Application by North Somerset Council for an Order granting Development Consent for the Portishead Branch Line – MetroWest Phase 1

Hearing Action Points arising from the Issue Specific Hearing 2 dealing with Environmental Matters (day 1 of 2) held virtually on Monday 11 January 2021

Drawing
**ASHTON VALE ROAD
PEDESTRIAN RAMP DESIGN**

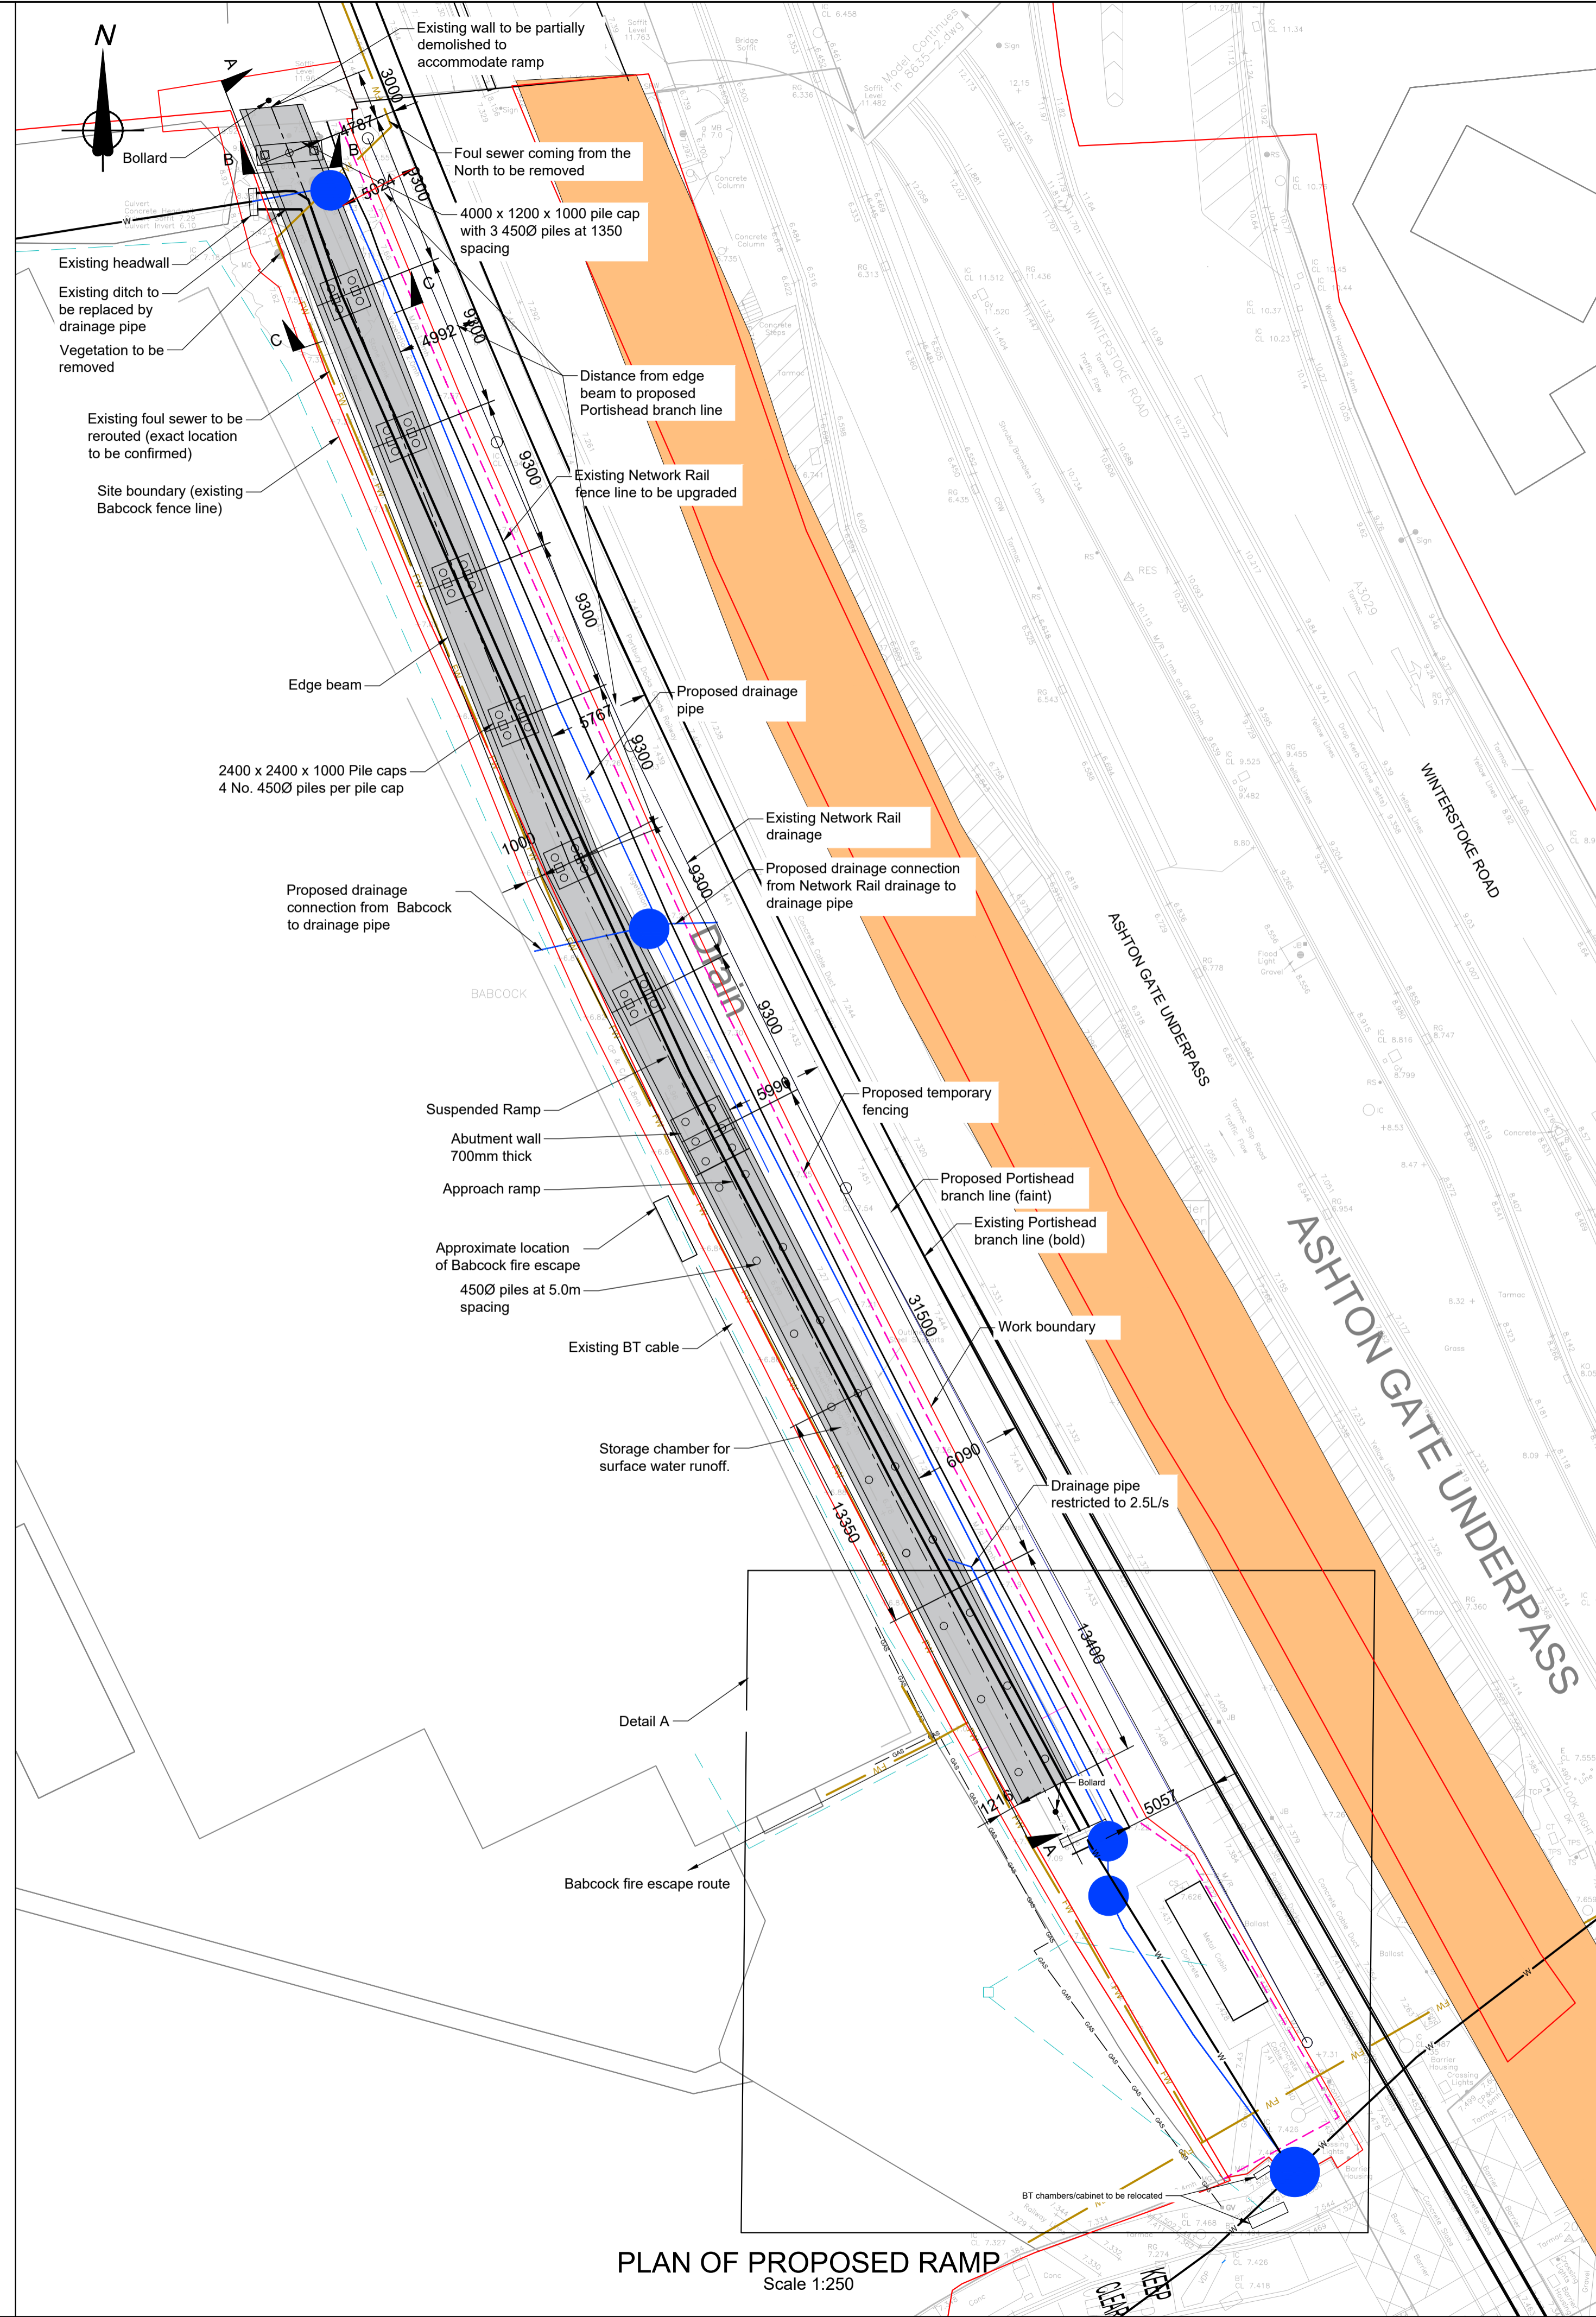
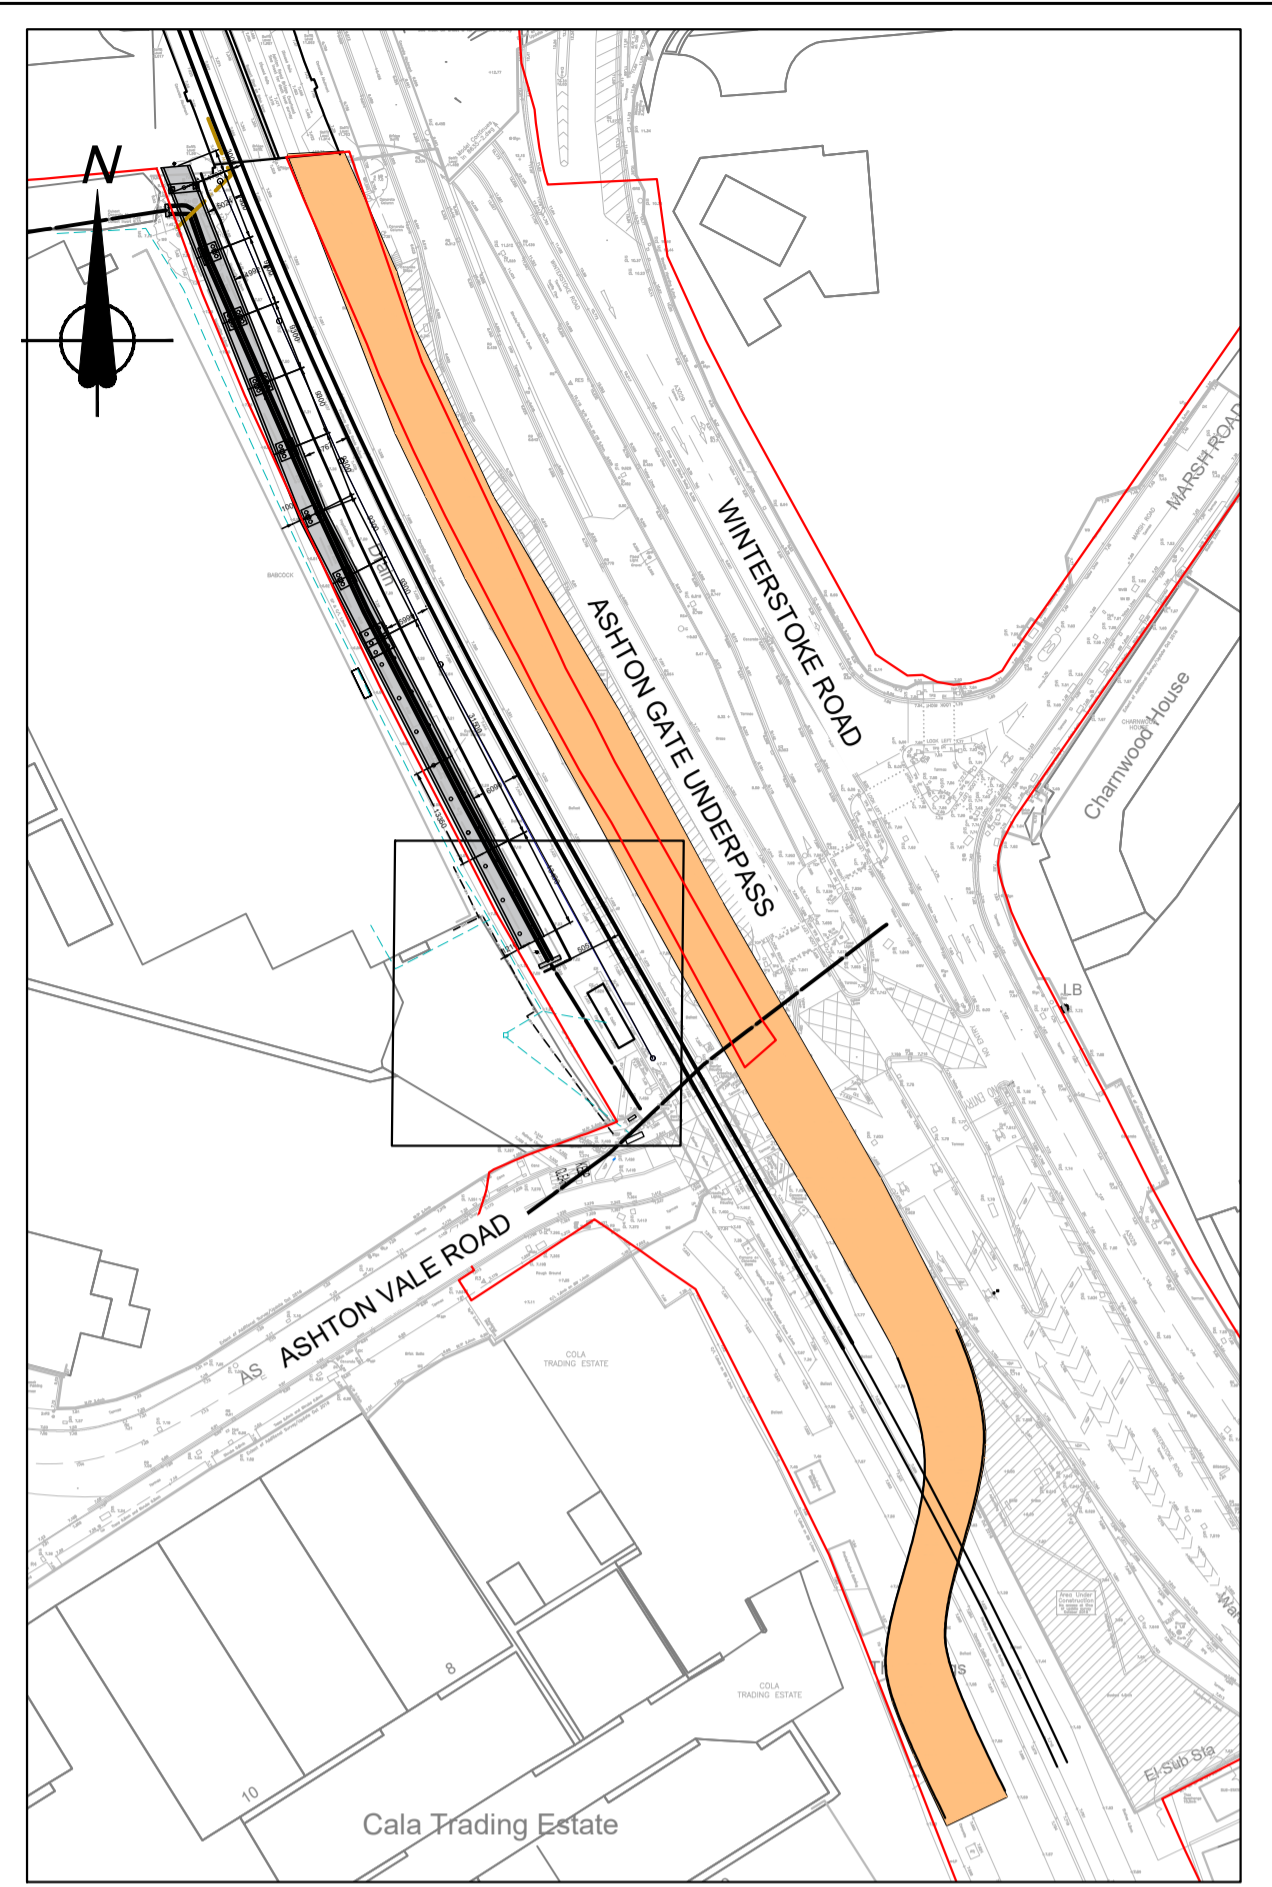
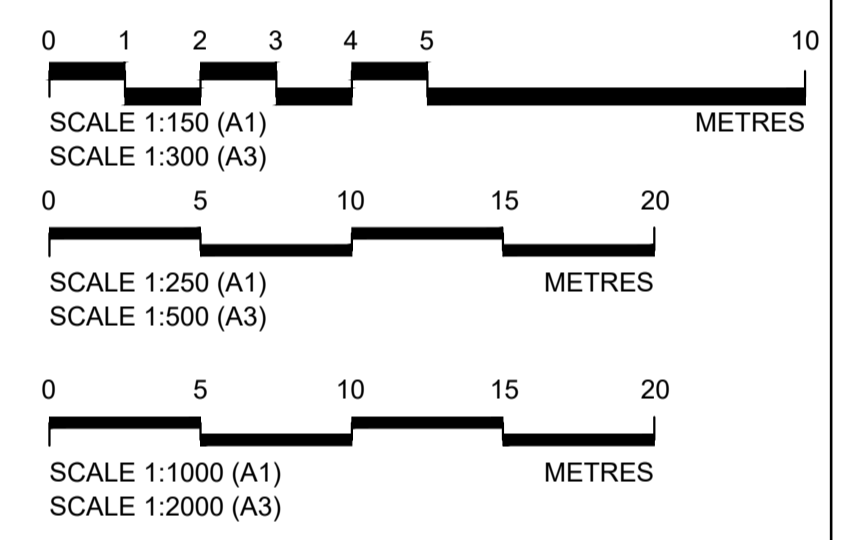
25	Applicant to respond to the response received from Mr Tonks at Deadline 4	Applicant	Deadline 5
26	Applicant to confirm whether the two minutes closure for the level crossing at Ashton Vale relates to the current freight trains or the proposed 2-5 car passenger trains. If it does relate to the current freight trains confirm how long these trains are compared to the proposed passenger trains	Network Rail/ the Applicant	Deadline 4
27	To provide an update on the progress with the s278 application for the proposed Toucan crossing	BCC/ the Applicant	Deadline 4
28	To provide further comments regarding whether or not Work No 27 (pedestrian footbridge and ramp at	BCC	Deadline 4

Ashton Vale Industrial Estate) would still be required in light of the comments made at the hearing about the possibility of it not being provided		
29	To explain, or signpost where in the application document it was considered, whether the provision of a pedestrian refuge in the centre of Royal Portbury Dock Road during the temporary diversion of the footpath/cycleway was considered and if it was why it was considered unnecessary	Applicant/ NSDC	Deadline 4
30	To review whether 'reduce speed' / traffic warning signs should be provided on Royal Portbury Dock Road during the period that the footpath/ cycleway would be diverted	Applicant/ NSDC	Deadline 4
31	To review whether Requirement 30 duplicates the need to provide a Construction Workers Travel Plan that would be secured as part of the CTMP in requirement 5. If it would, to consider which mechanism would best deliver the outcome required and amend the dDCO as necessary	Applicant/ NSDC	Deadline 4
